**AB/7/21/L**

*Vyne Cottage 33 Mount Pleasant Arundel BN18 9BD*

*Listed building consent for the replacement of 12 No. windows & 1 No door*

Drawing Title:
Proposed Door and Details

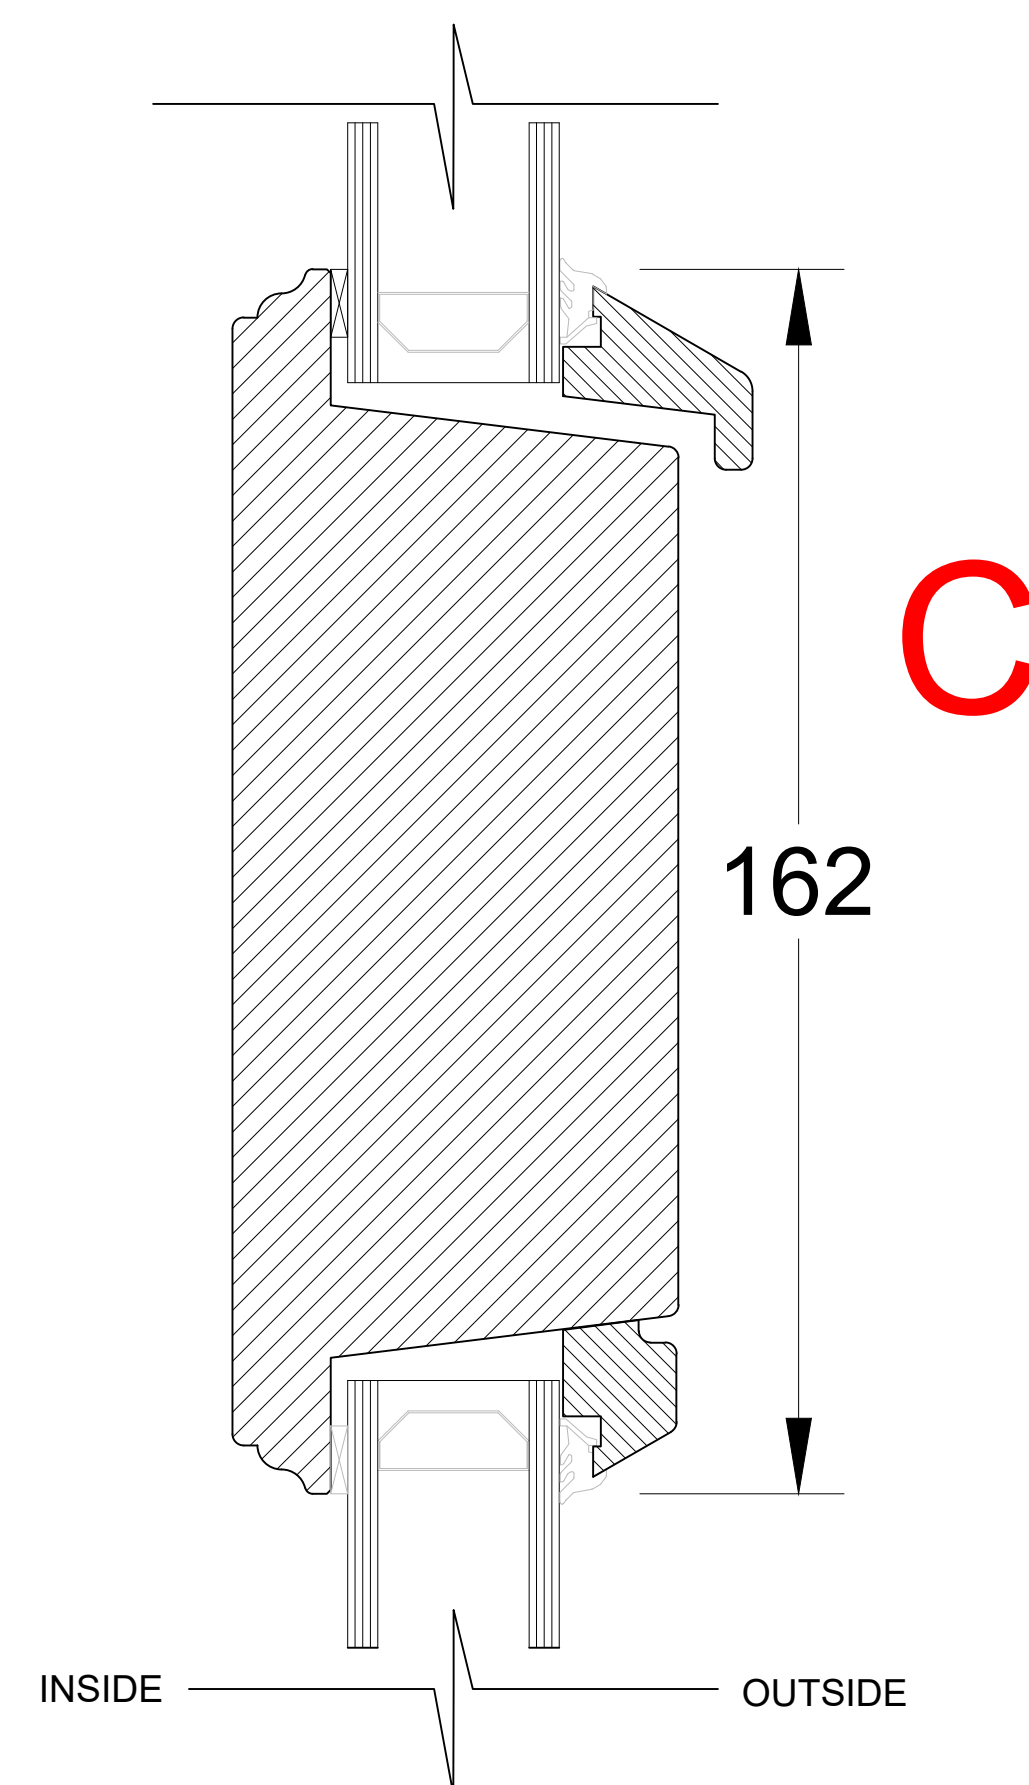
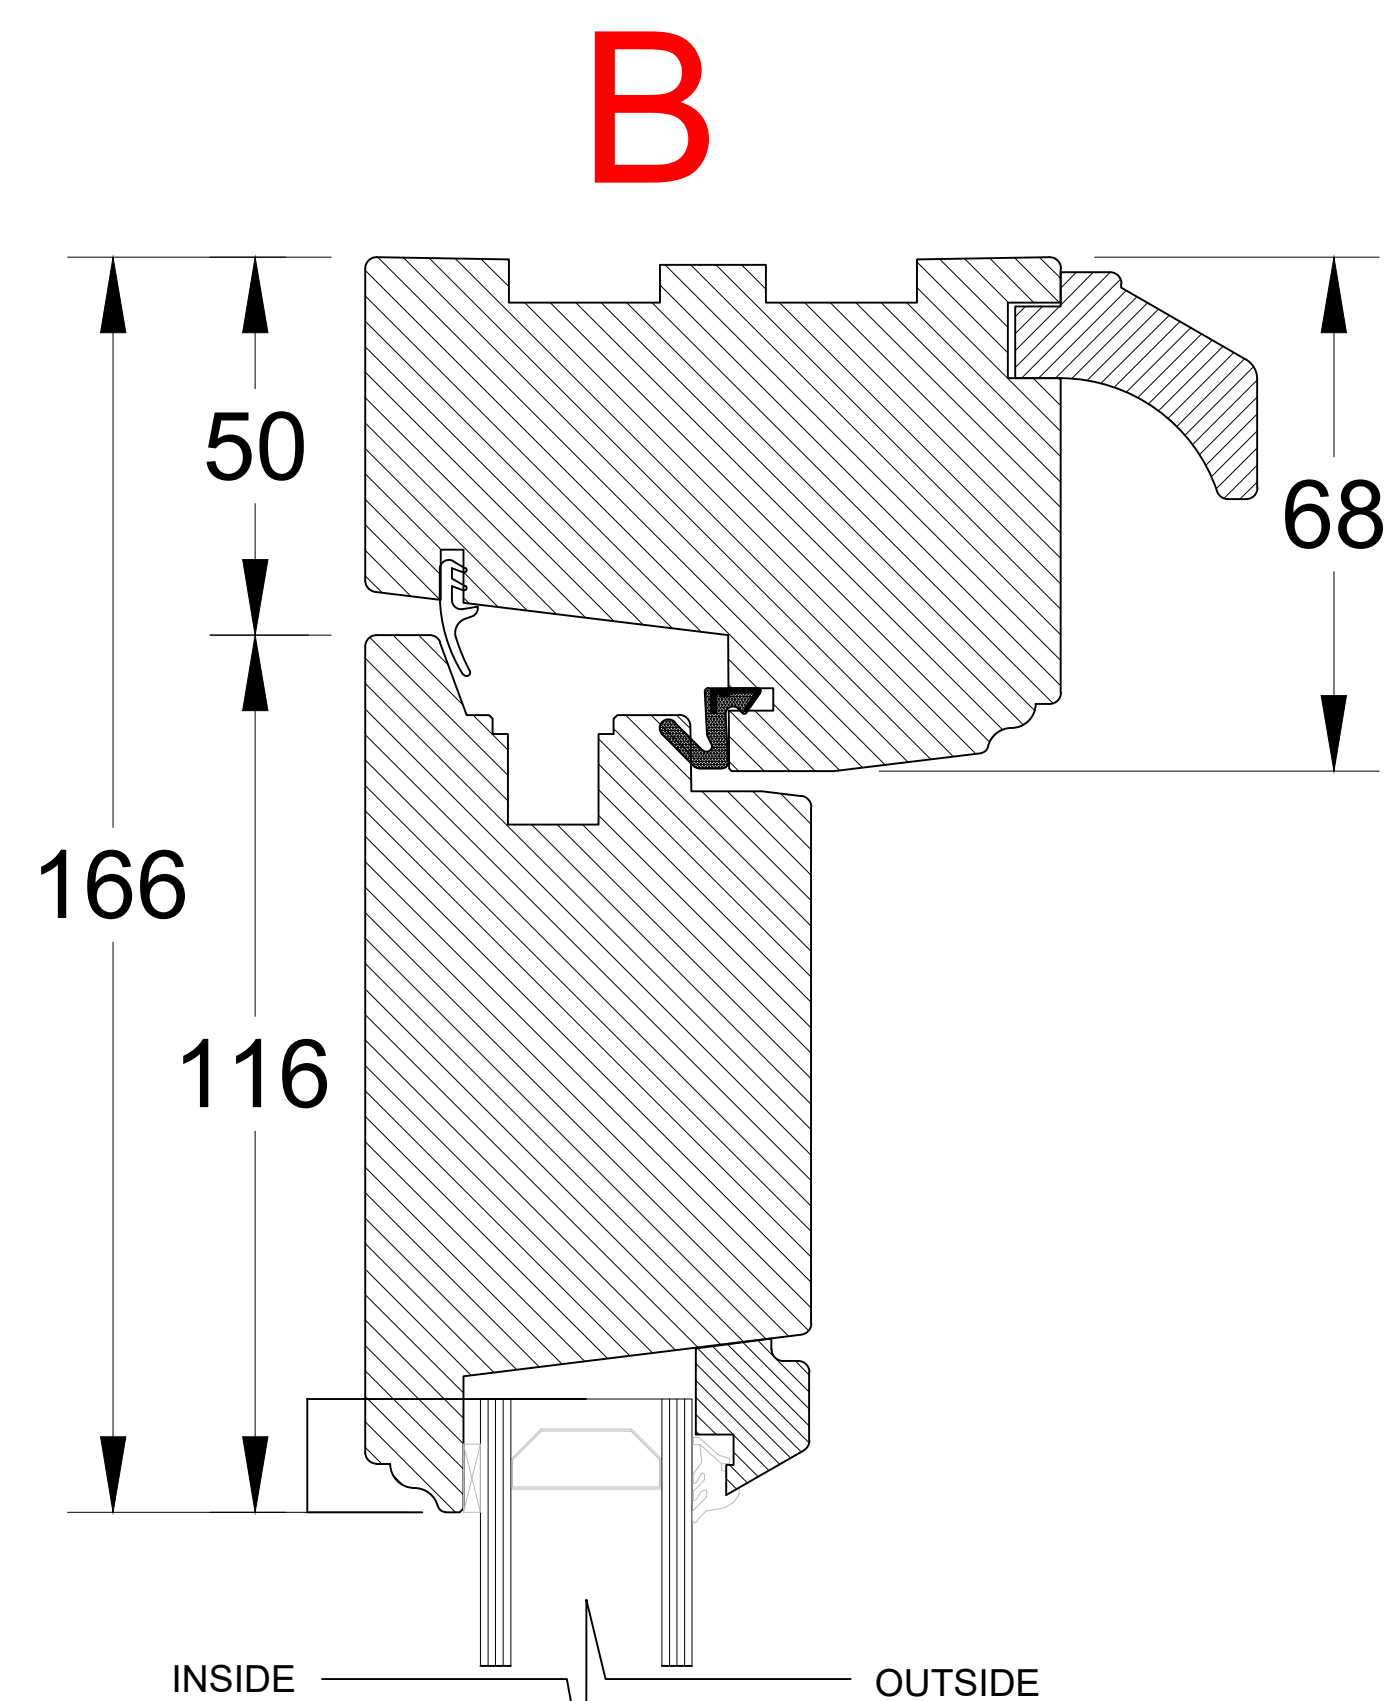
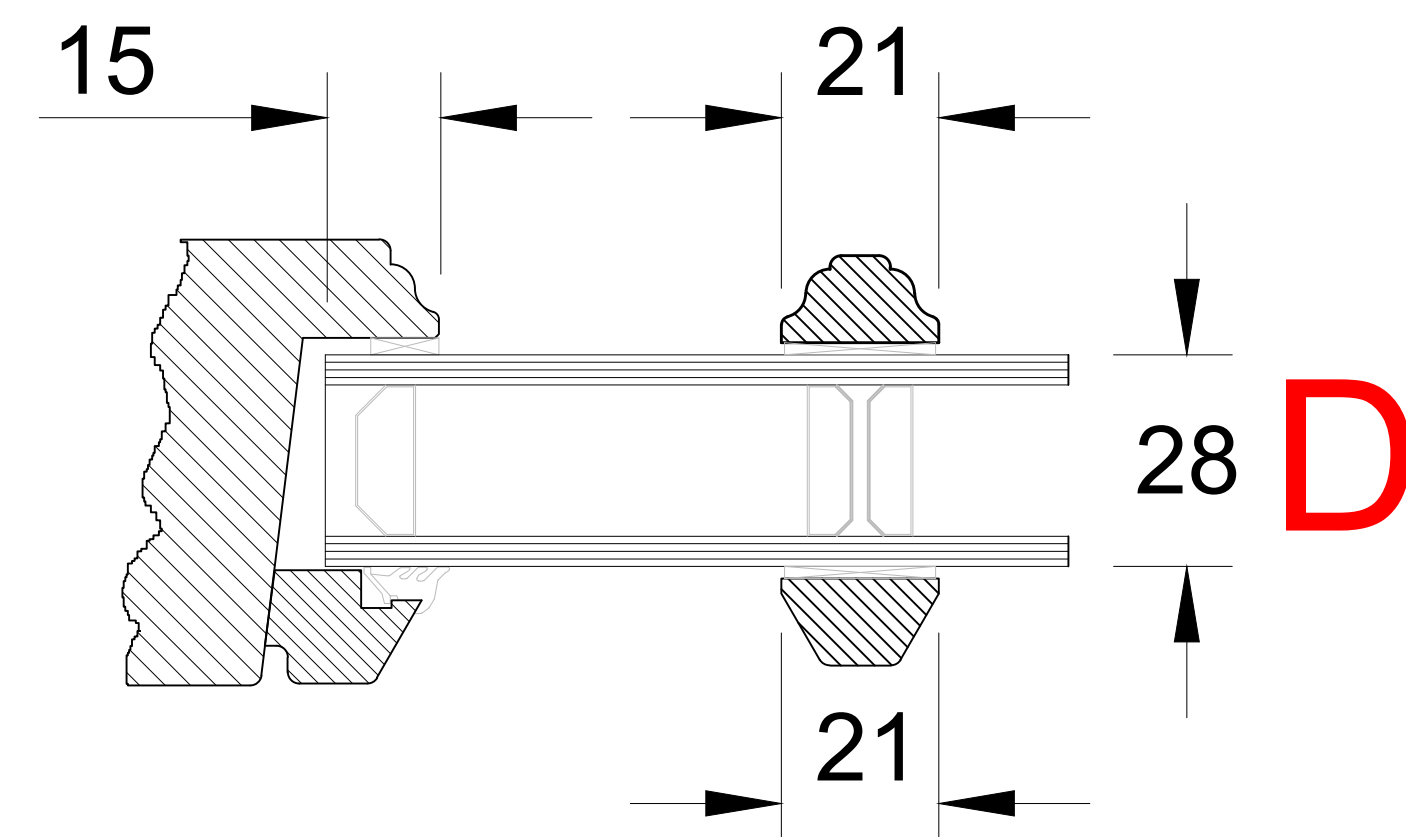
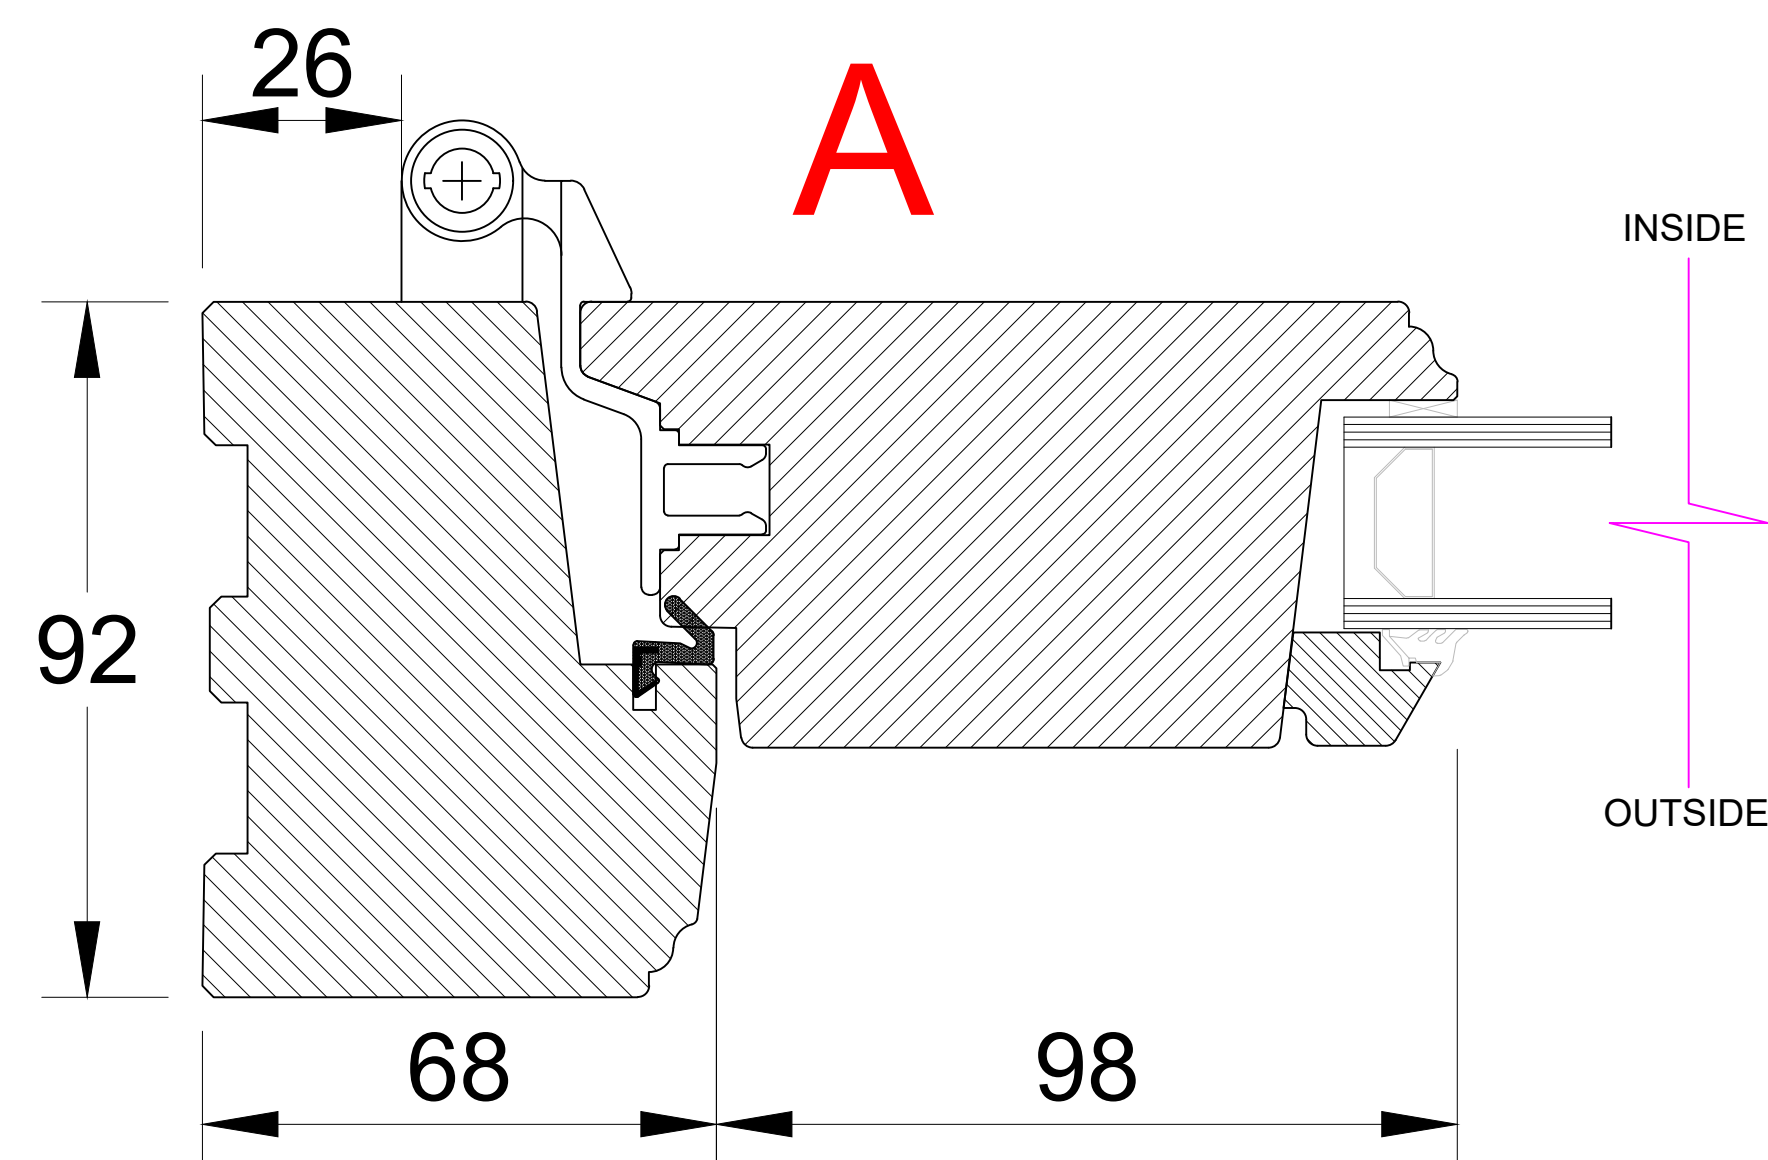
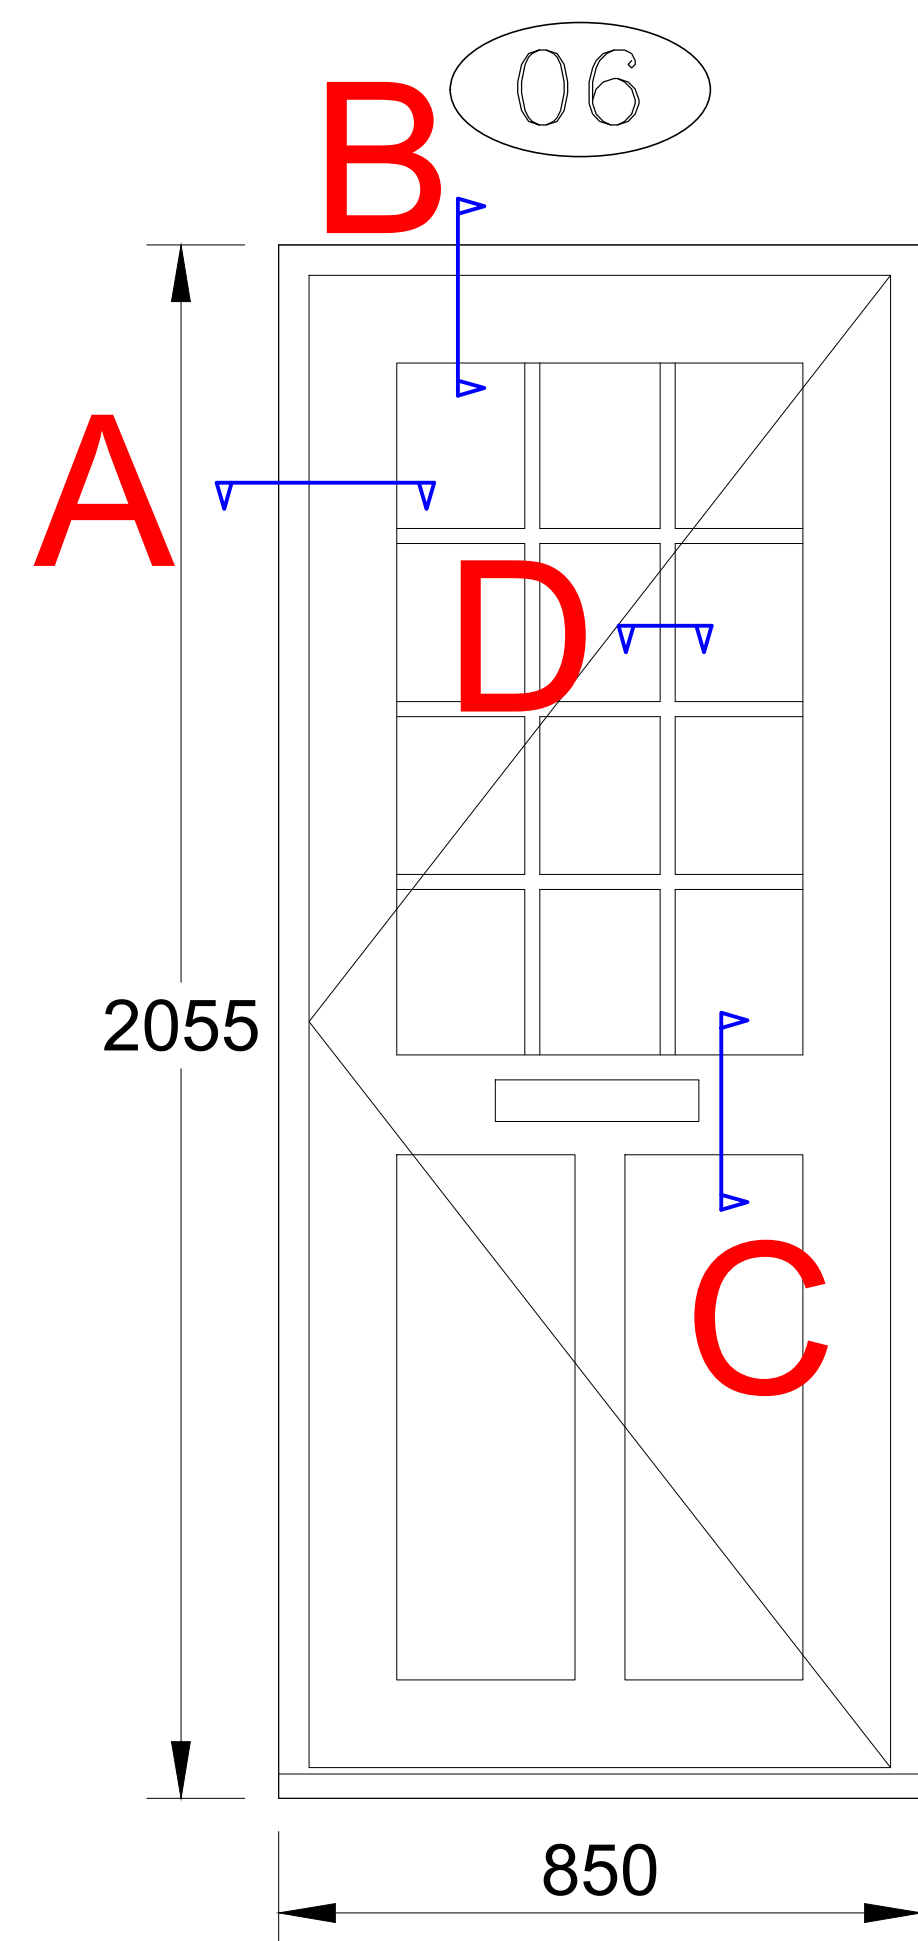
The proposal is for timber windows which incorporate 28mm double glazed units, along with the use of thermal spacers will not only increase the perception of modern, standard windows, but also affect the design of the windows themselves. Traditionally, where windows have glazing bars, these form part of the structure of the window. False glazing bars applied to the surface of the window are therefore historically incorrect, and aesthetically unconvincing. The use of applied glazing bars is therefore not appropriate for a listed building and should be integral to the windows. This type of double glazed unit and window design is therefore not appropriate for a listed building and is considered to cause harm.

An alternate approach would be to revise the design of the windows so that the much slimmer glazed units are used alongside windows/doors which include fully functioning glazing bars. However, at present of the proposal is not acceptable and is considered to be harmful.
